Response to Planning Application

From: Arun District Council Greenspace

Application ref: P/38/20/DOC

Description: Approval of details reserved by condition imposed under ref P/70/19/RES relating to Condition Nos 4 - paved & gated access, 6 - charging of electric vehicles and 9 - new signage to encourage responsible dog ownership.

Drawing Title:
Public Open Space, footpath link Plan

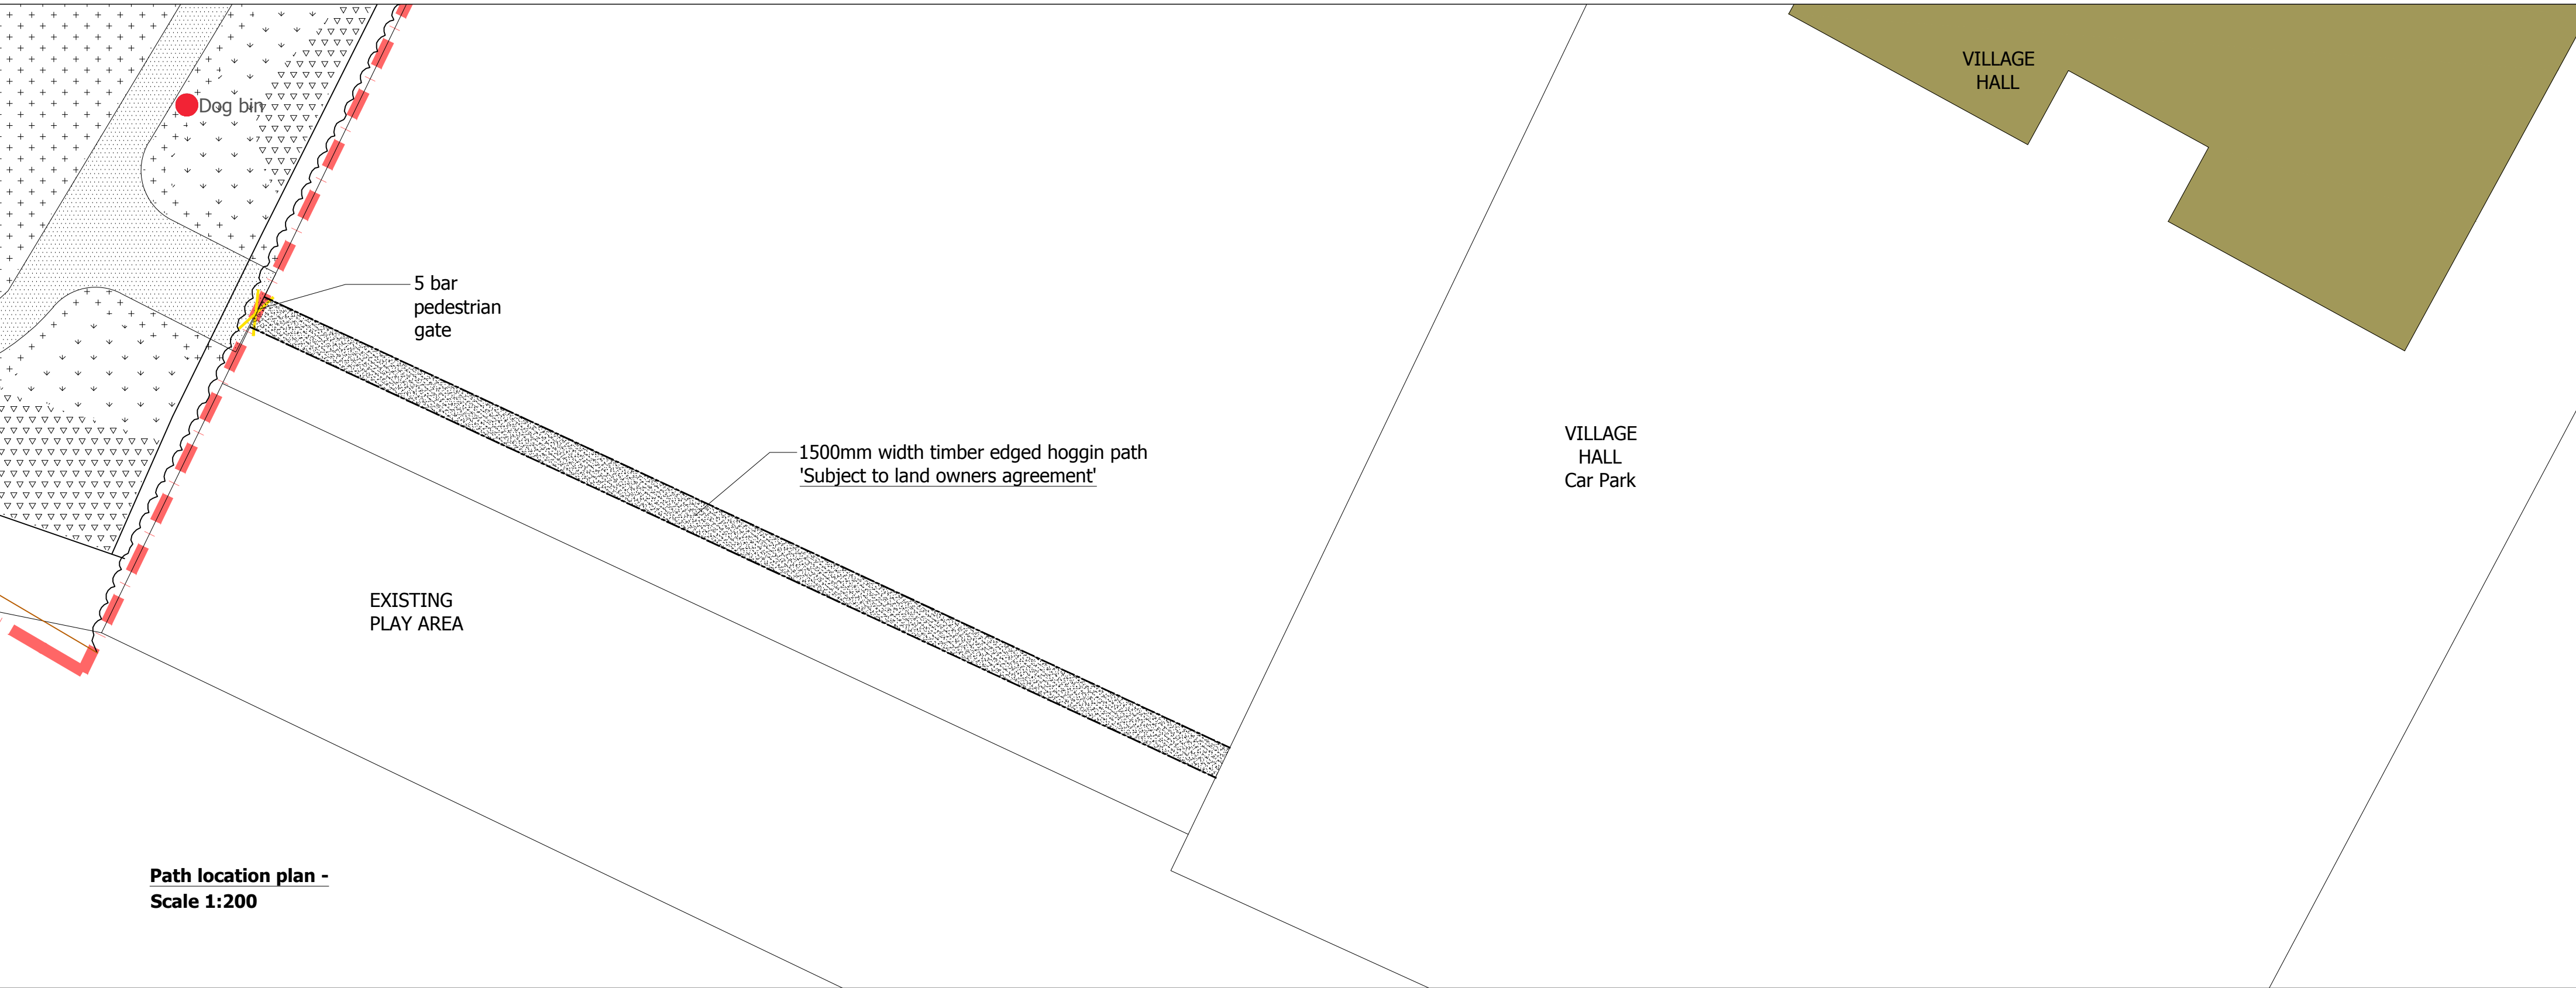
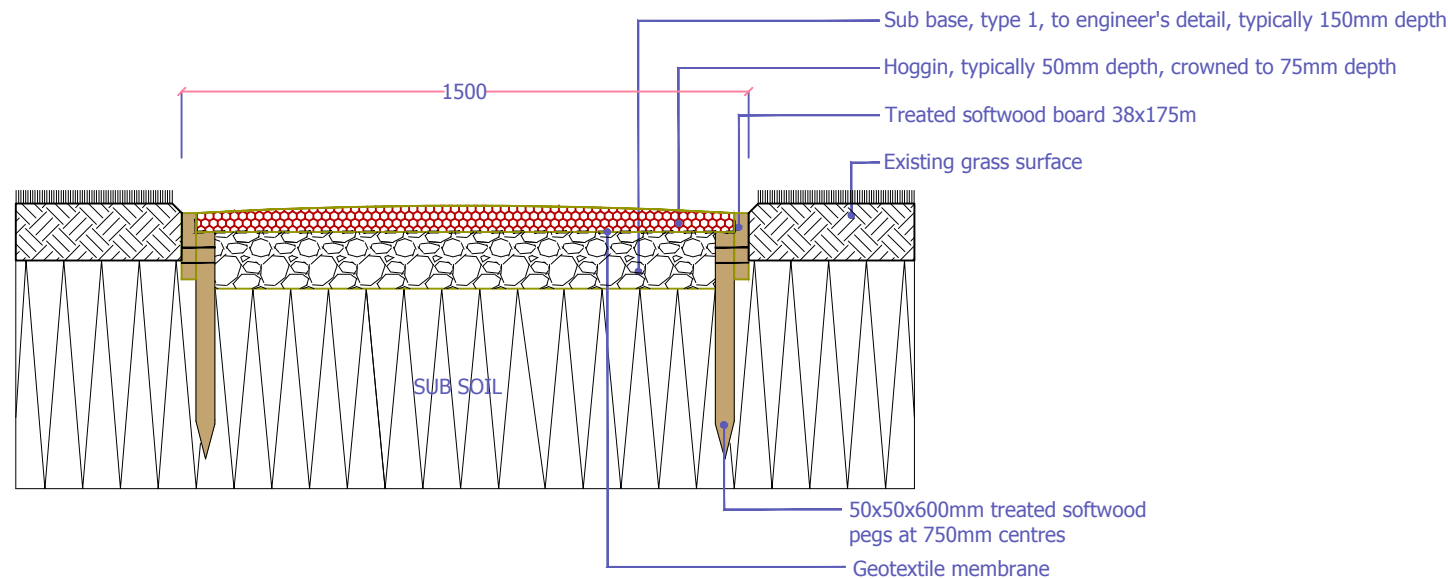
Following submission of POS Footpath Link Plan dwg no M323-360 Rev P1 I can confirm that this does contain sufficient detail re footpath construction and gate proposals, therefore I would **recommend the discharge of Condition 4** on this application imposed under P/70/19/RES

Public Open Space Plan
Dog Walking Signage Strategy

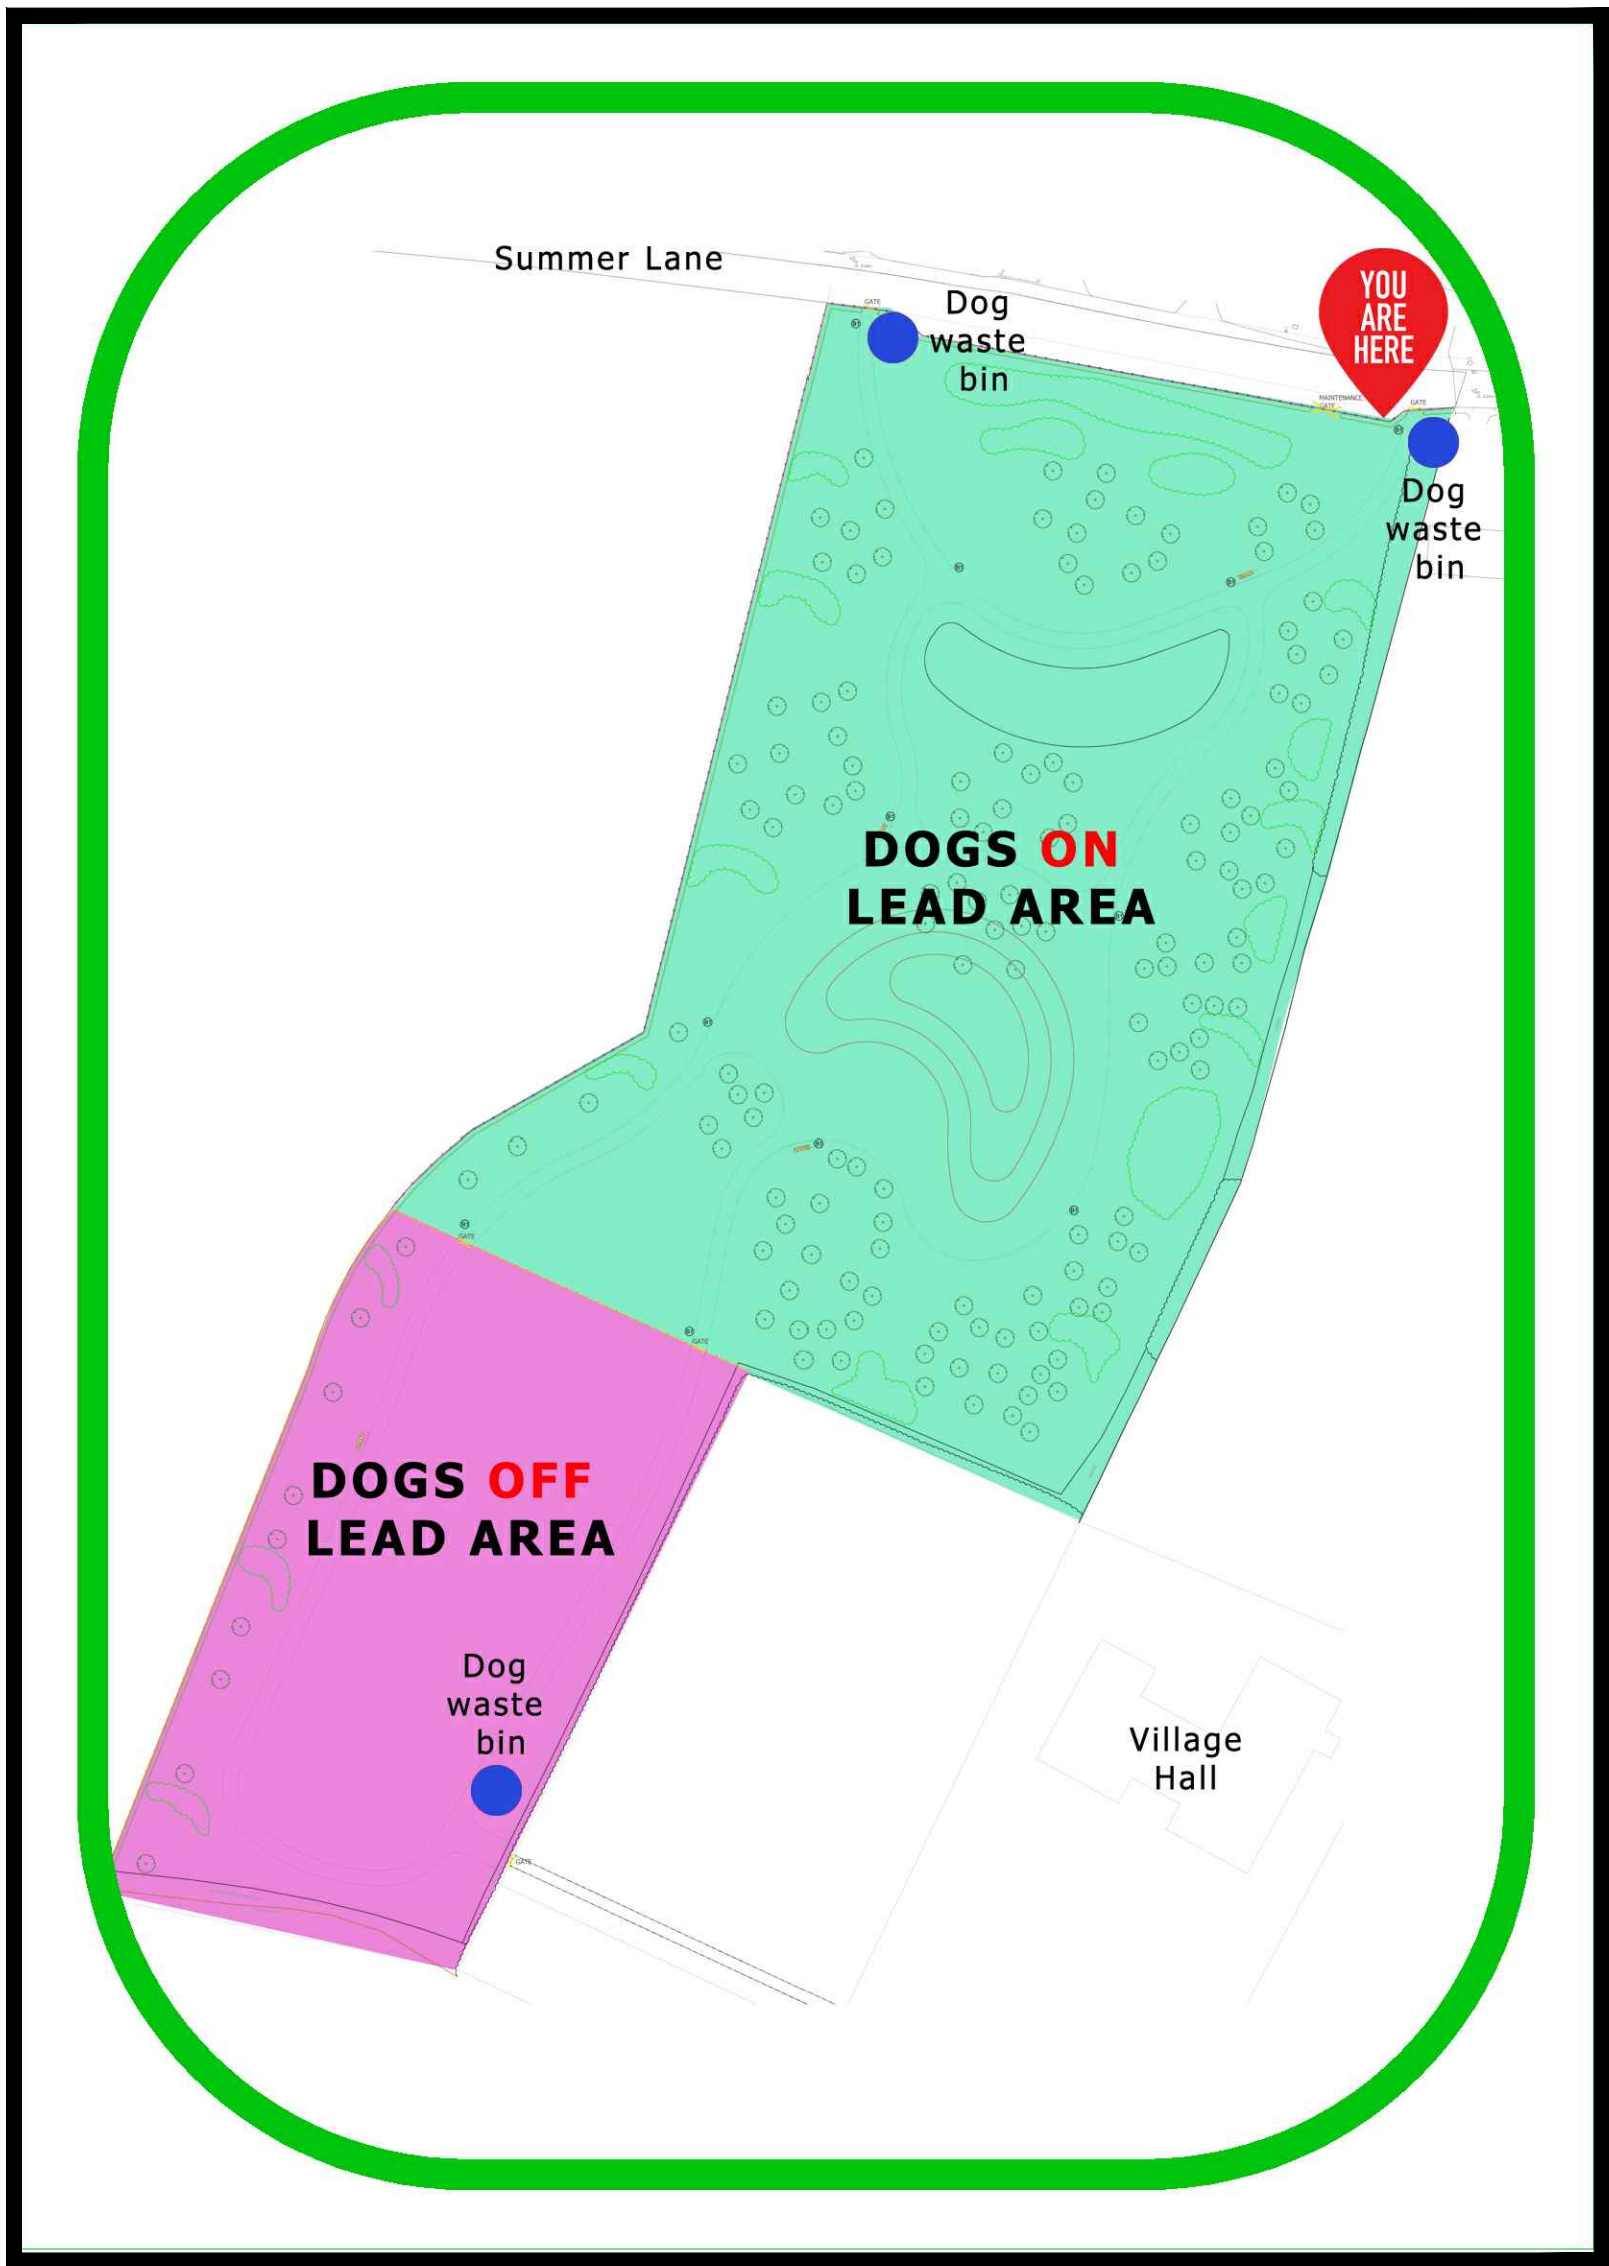
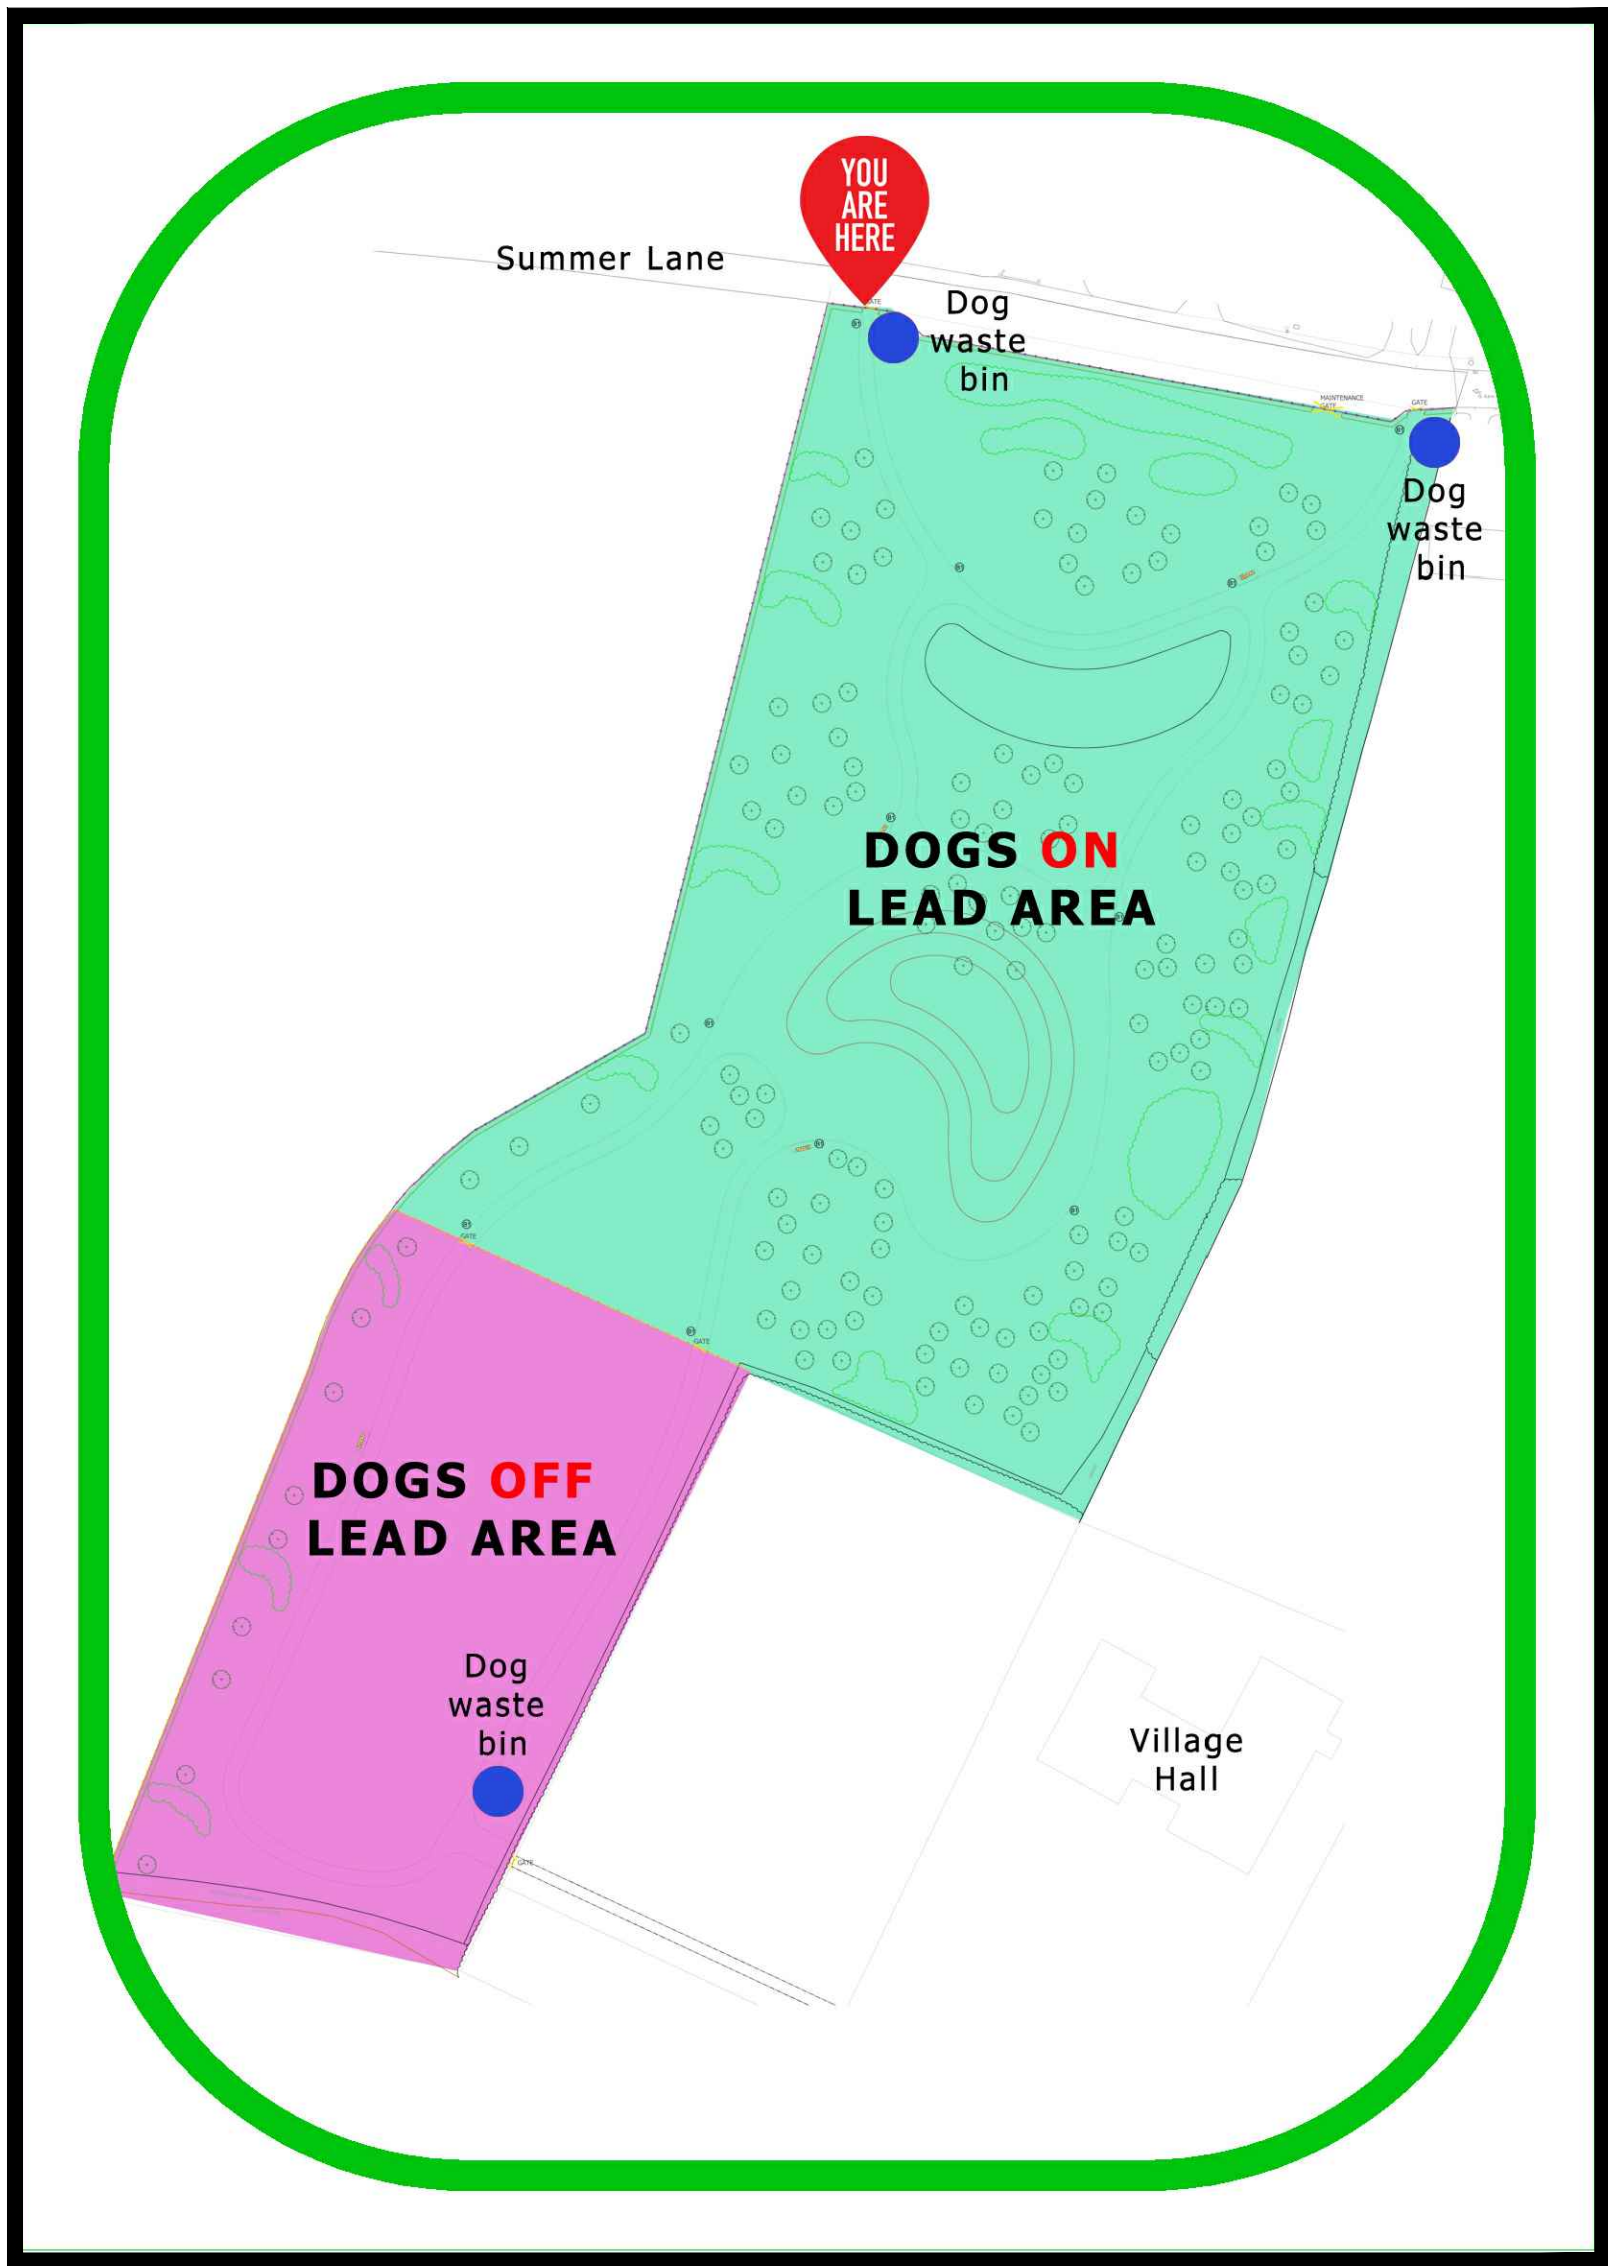
Following submission of POS Dog Walking strategy Dwg no M323-355 Rev P1 I can confirm that this does contain suitable information to inform the public of the requirements in this area, therefore I would **recommend the discharge of Condition 9** on this application imposed under P/70/19/RES
